Recommendation Report for Works to Tree(s) on trees subject to a Tree Preservation Order (TPO)

REF NO: AW/125/20/T

LOCATION: 229 Aldwick Road
Aldwick
PO21 3QG

PROPOSAL: Re-pollard back to main stem to 1 No. Weeping Willow tree.

REF 1

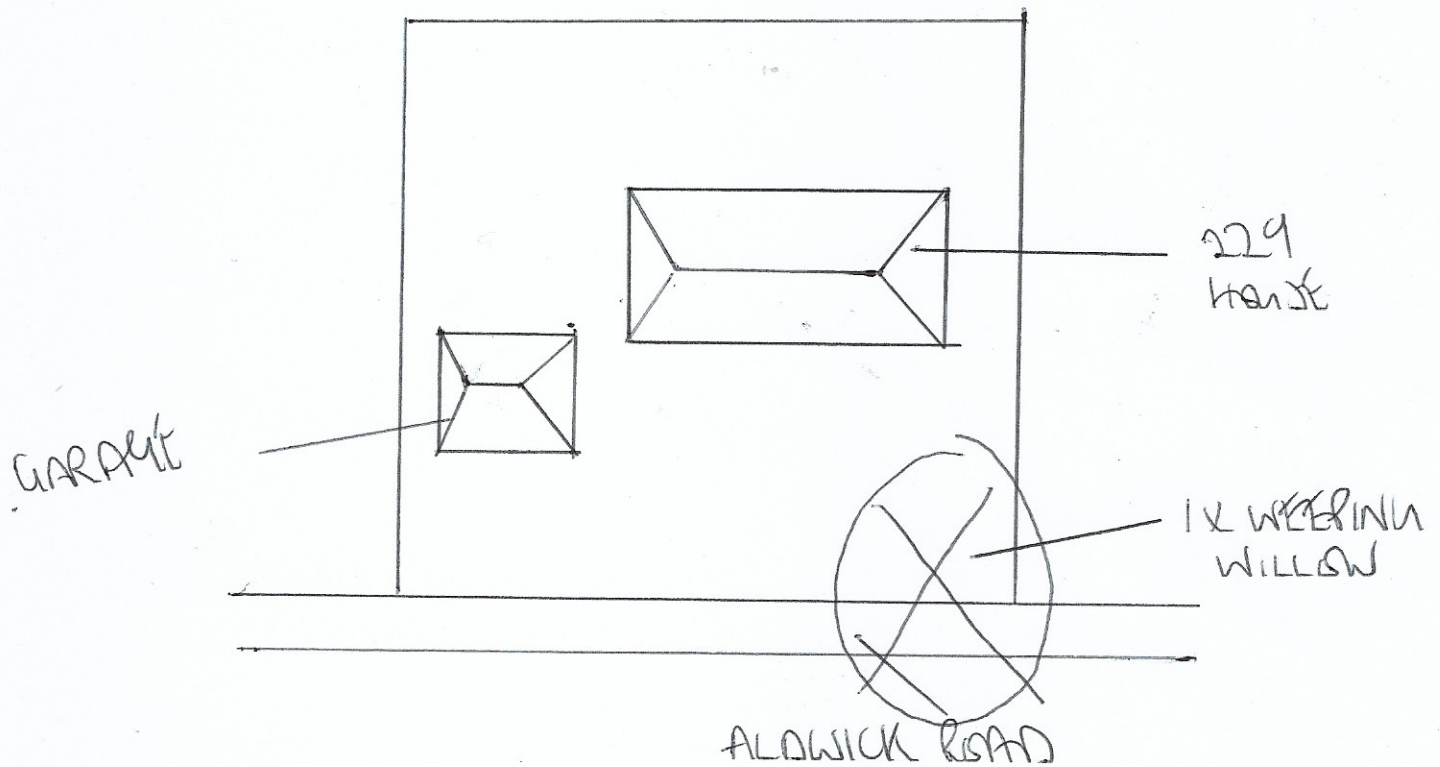
Outwardly and from a distance this tree appears to be in a fine physiological state. Small cavities associated with historic pruning wounds suggest a degree of stem decay.

- It is highly visible from numerous properties and to users of the public highway (footway and carriageway). A 'pollarded' tree but crudely initiated with a 'topping out' of the main stem and severe truncation of limb framework. As such, the tree provides visual amenity only during the crown renewal/recovery stage. That has been vigorous since the last operation (c2012) and typical of a healthy example of its type, although asymmetric due to competing with willow trees on neighbouring property (recently re-pollarded).

· Repeat operations such as now being asked for by the applicant will be necessary throughout the remaining lifespan of this tree, to achieve a degree of structural integrity appropriate for its location.

· The proposal to reduce its overall height and spread with a view to restricting its growth is justified and consistent with previous works approved by the Local Planning Authority.

· While a temporary loss of aesthetic value is inevitable, satisfactory crown renewal and recovery should occur if the work is undertaken to a high standard and at an appropriate time of year.

- 1 Part a) Where whole branches are to be removed and final cuts made close to the trunk or branch union they are to be made as shown in Figure 2 of BS3998:2010

Part b) Where branches are to be shortened back the final cuts are to be made at the correct angle shown in BS3998:2010 and adjacent to a live bud or lateral.

Part c) The removal of crown material which has developed since the last operation must be done sympathetically and with respect to established 'knuckles' so as not to extend beyond the point of origin.

· The long-term vitality of this tree is best respected when significant pruning work such as proposed, is undertaken during the late-spring to summer period (May to August). The work proposed should only be undertaken during this period.
